Town & Country Planning Act 1990 (as amended)
Town and Country Planning (Development Management Procedure) (England) Order 2015
Application for approval of matters reserved by condition imposed under M/39/17/HH relating to
condition No.4 (Landscaping) & 6 (Drainage)
Middleton House Yapton Road, Middleton,

Condition Number 6

Arun District Council have decided to **REFUSE details reserved by condition for the following reasons:**

Date May 2018	Approved by
Drawn by Mark Tuson	Scale - 1:50
Notes	
Client Mr S Gore	Site Middleton House Yapton Road Middleton on Sea PO22 6DU
MT Planning & design For all your planning needs	
07950 887579 mtplanning@hotmail.co.uk	
REVISION:- A	DRAWING NO:- MT / 1547 / 1

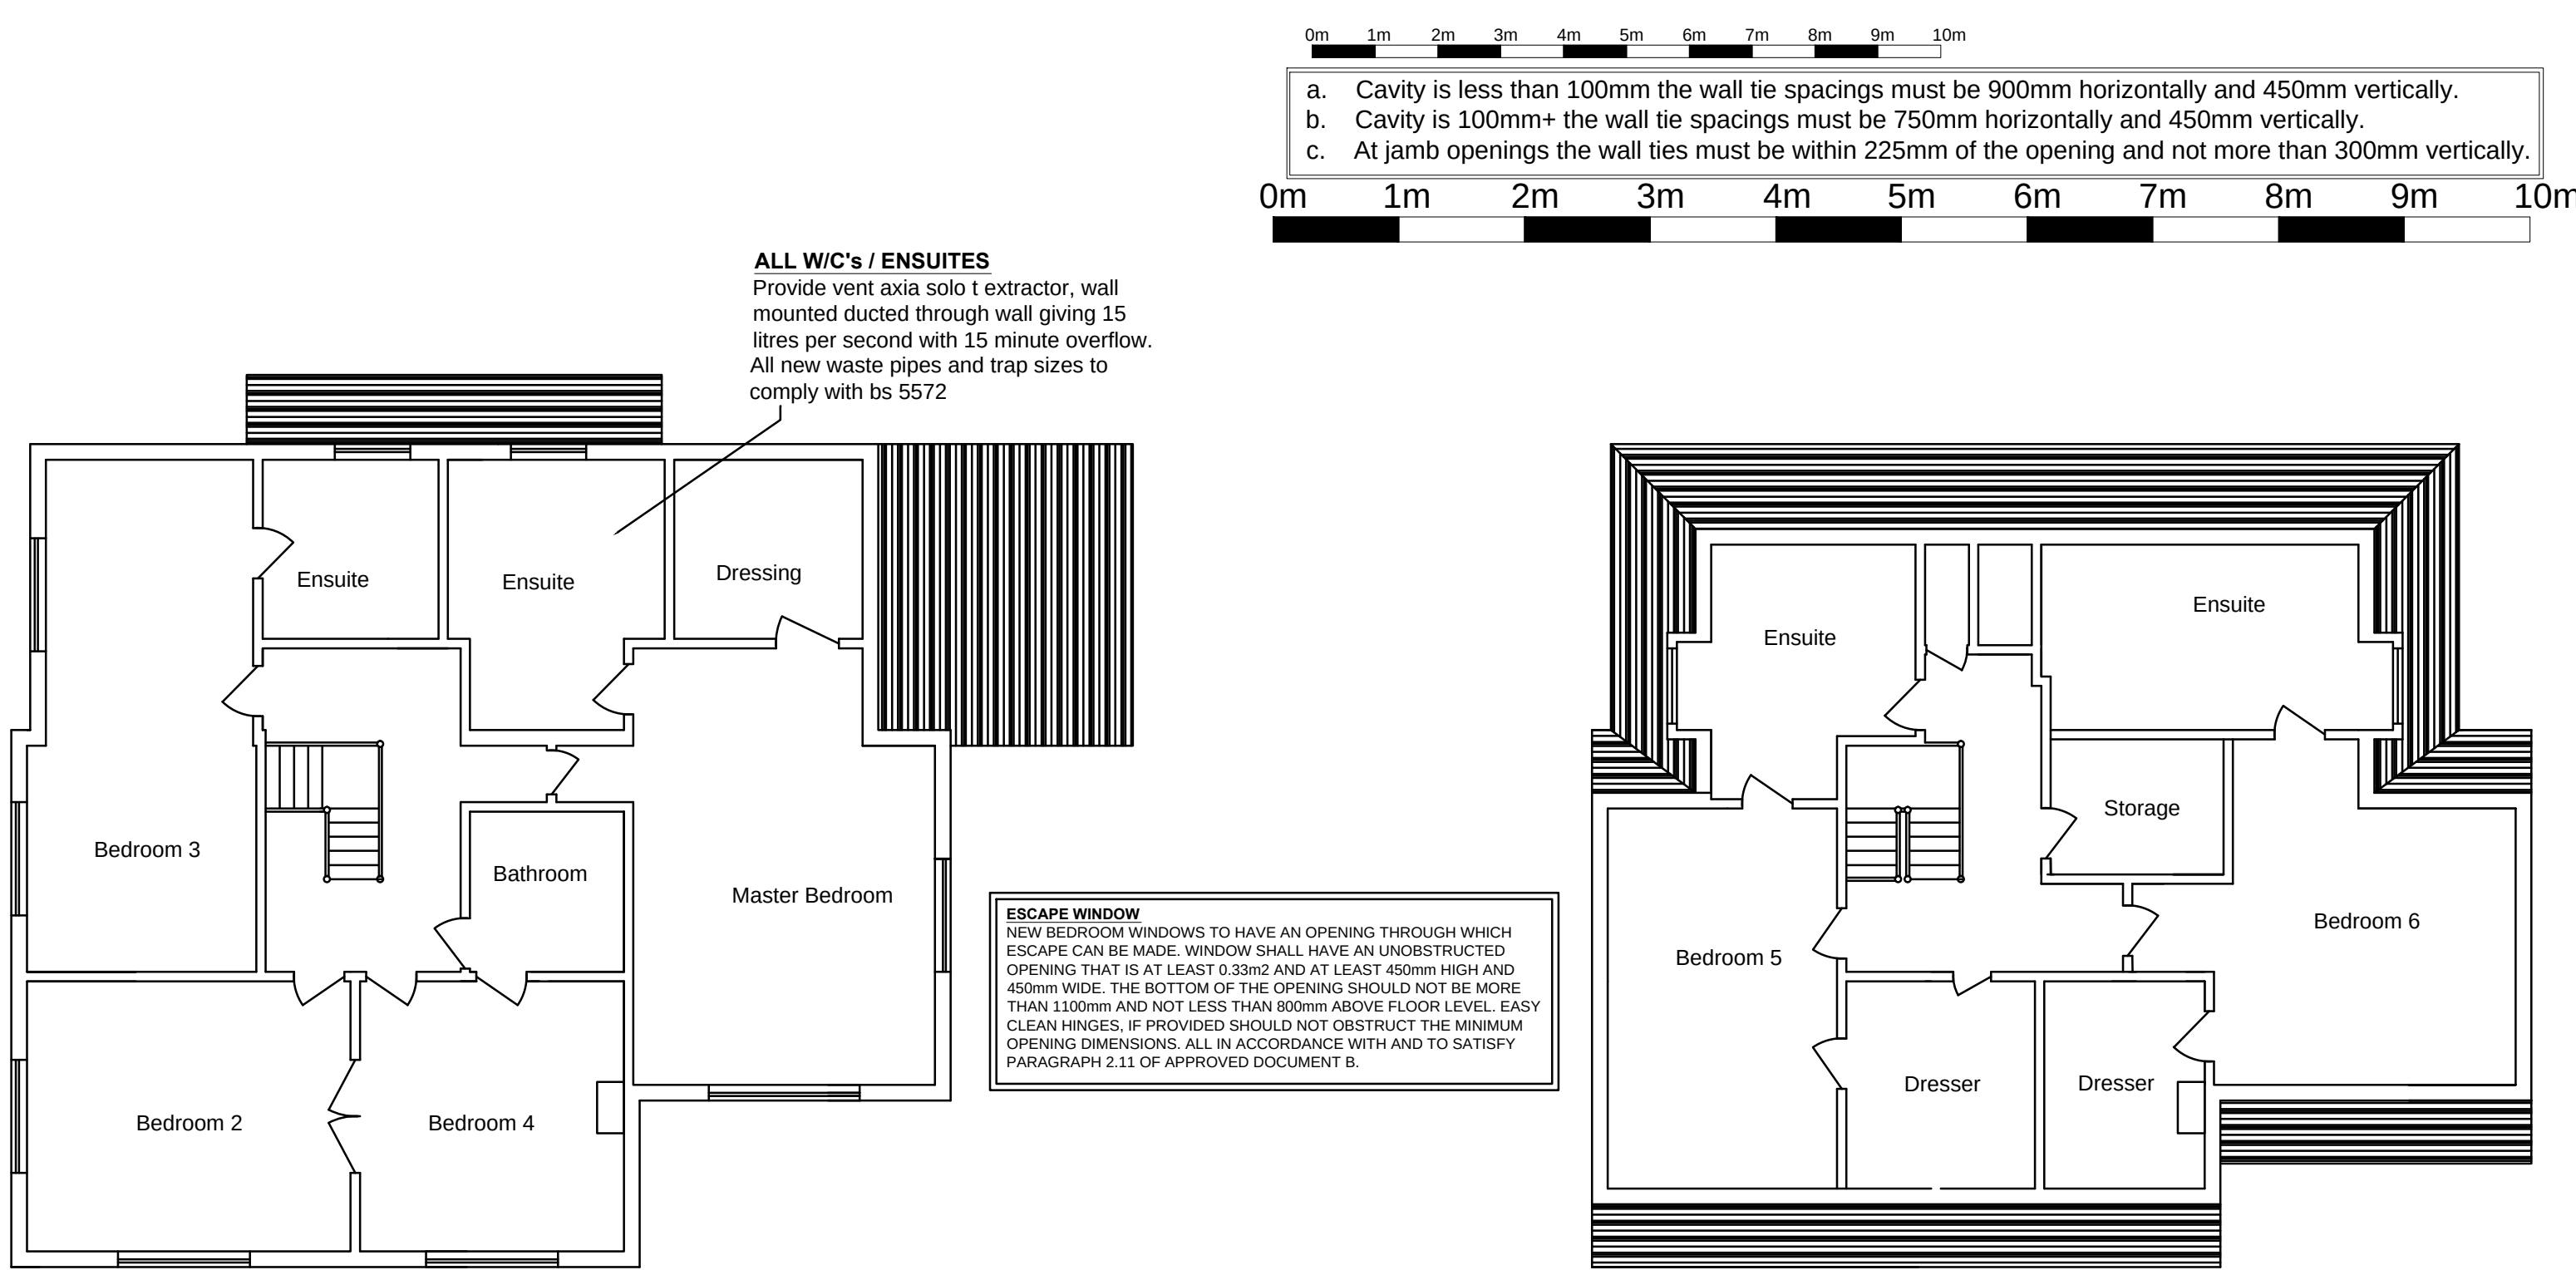
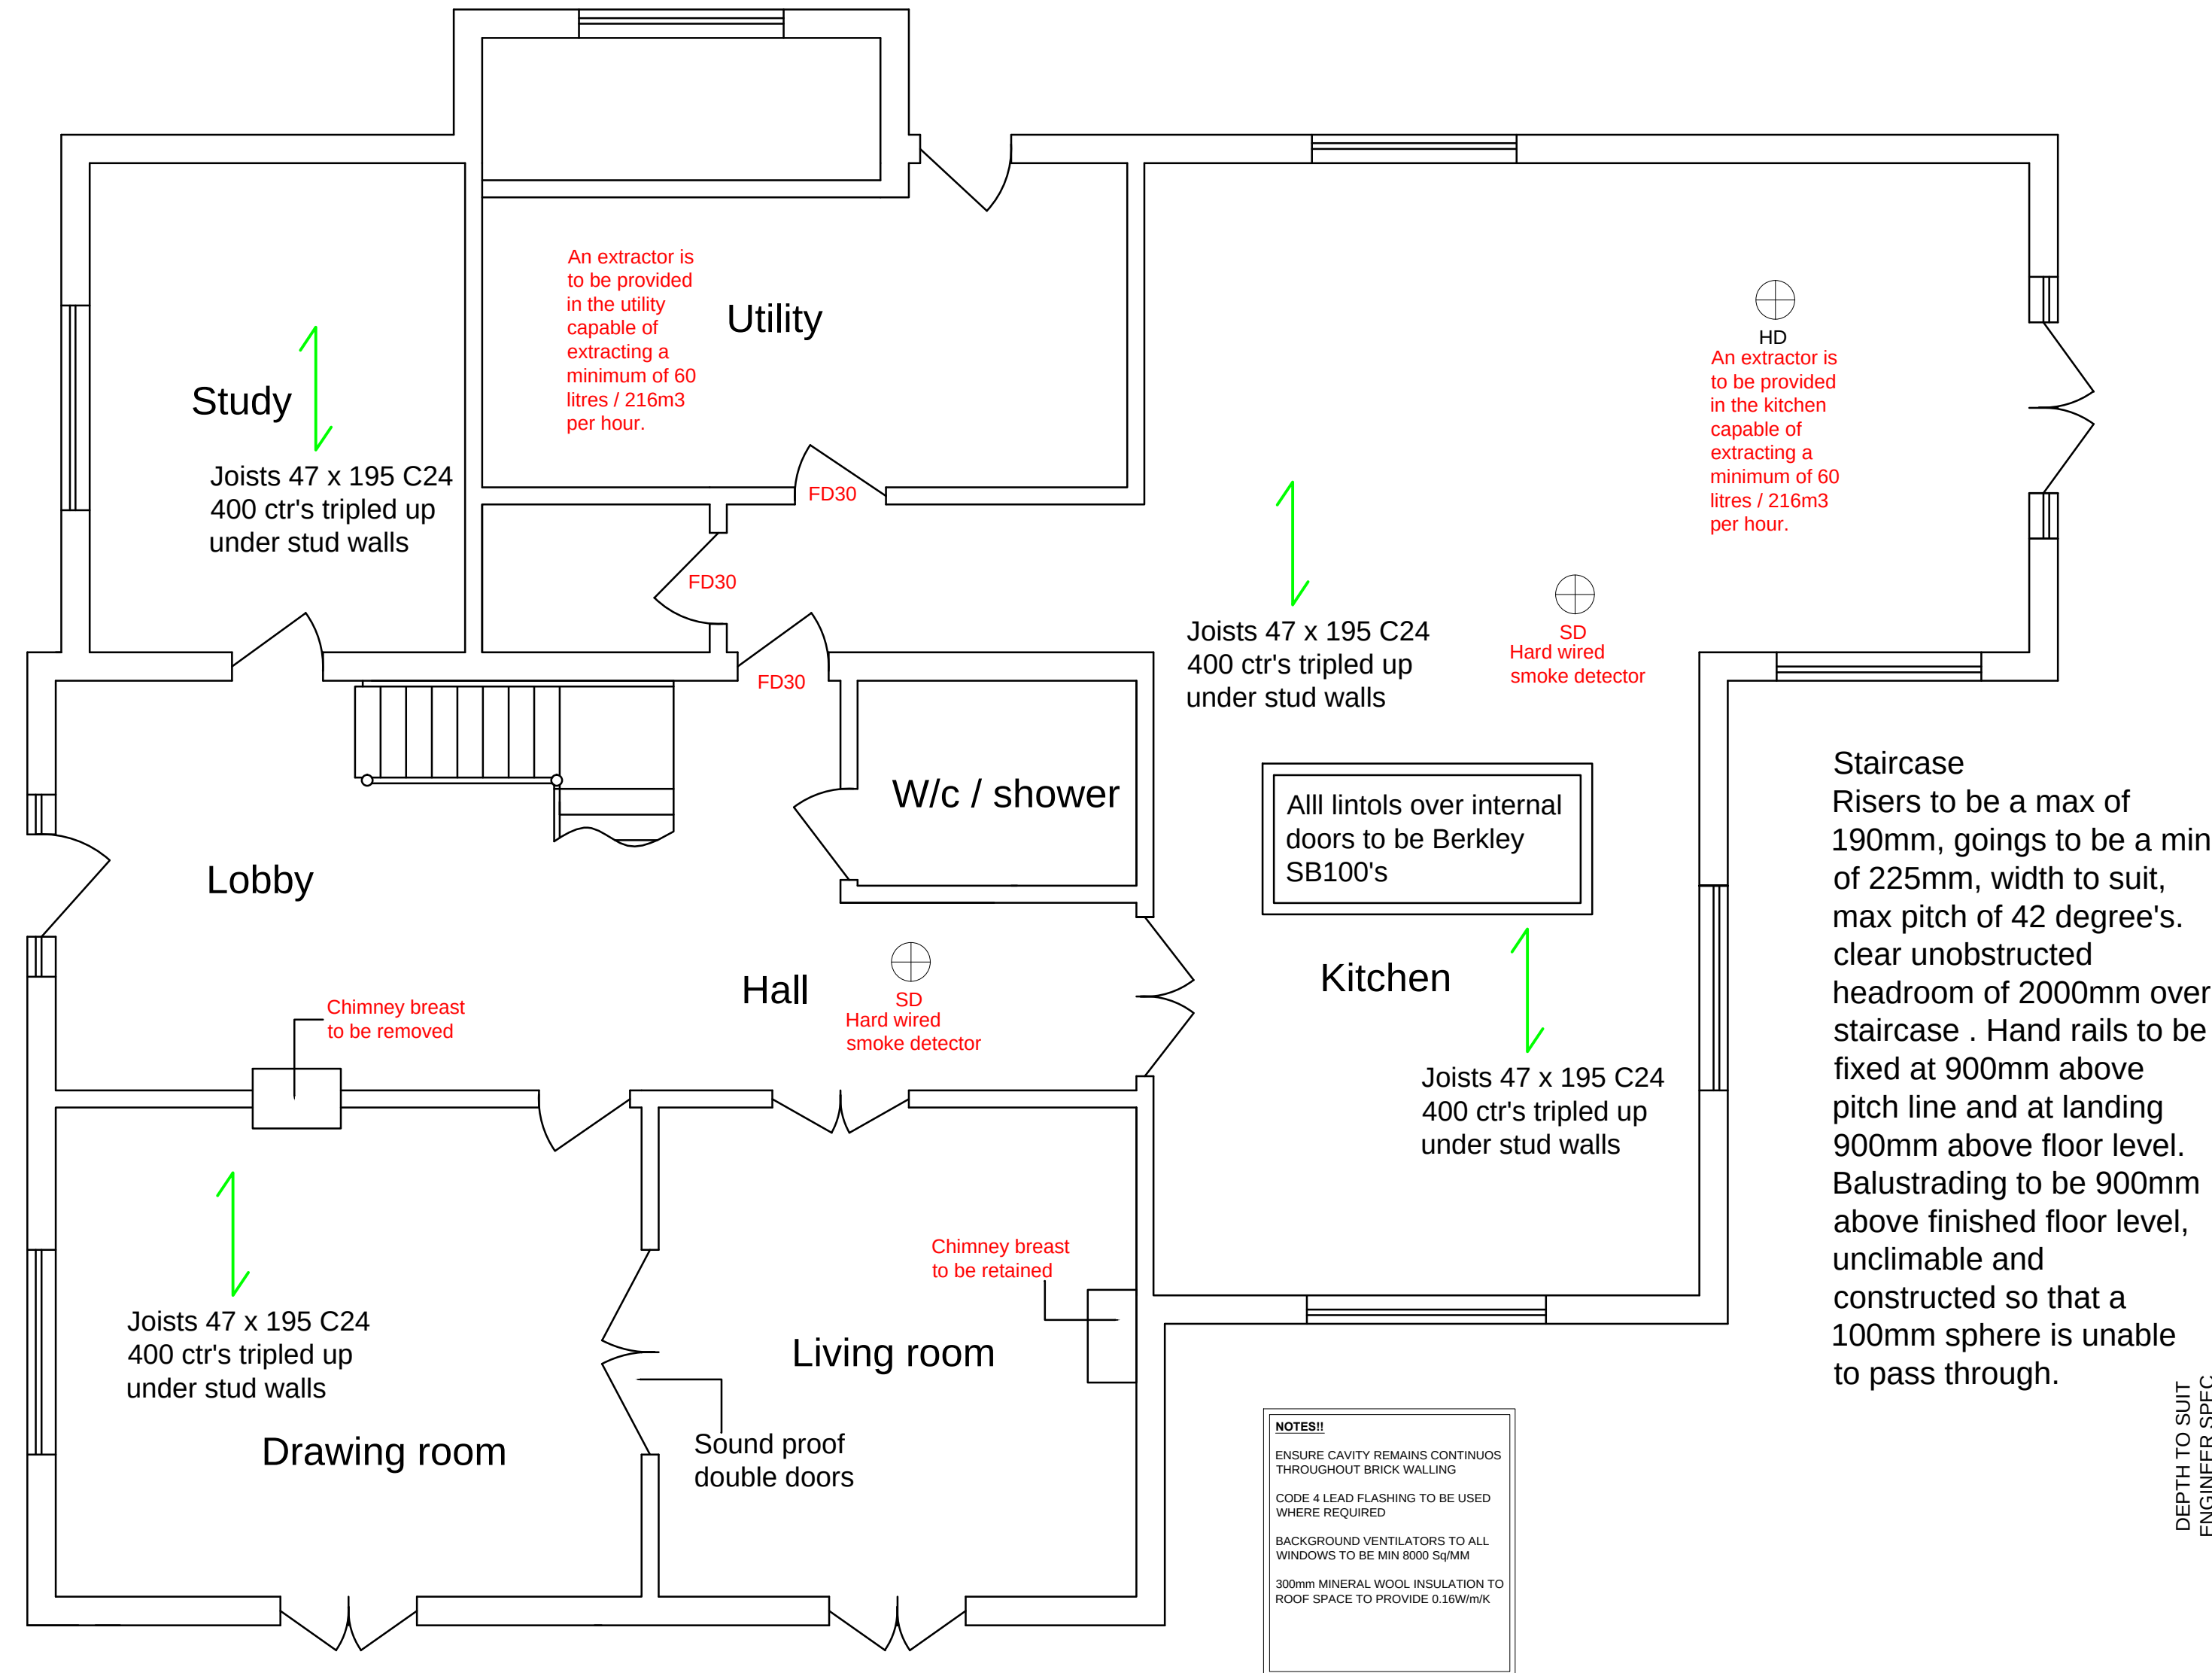
. No winter groundwater monitoring results have been submitted as part of this application. Infiltration test results have been provided, however they do not detail when the tests were completed, i.e. if they were completed in the winter. Please provide these.

o The infiltration rate supplied does not correlate to checks conducted on the percolation test results. An infiltration rate of $5.88 \times 10^{-6} \text{ ms}^{-1}$ should be used.

o Calculations, drainage layout plans, and construction detail drawings should be submitted as docdeci

part of the DOC application.

- o Calculations should demonstrate that the 1 in 100 year plus 40% climate change event for storm durations ranging from the 5 minute to the 24 hours.

- o Drainage layout plans should include invert levels, cover levels, and dimensions of soakaways. In addition dimensions of pipes should be labelled on the plan. Silt traps should be provided upstream of any connections into soakaways.

- o Construction detail plans should include soakaways, protection details of pipes, and silt traps
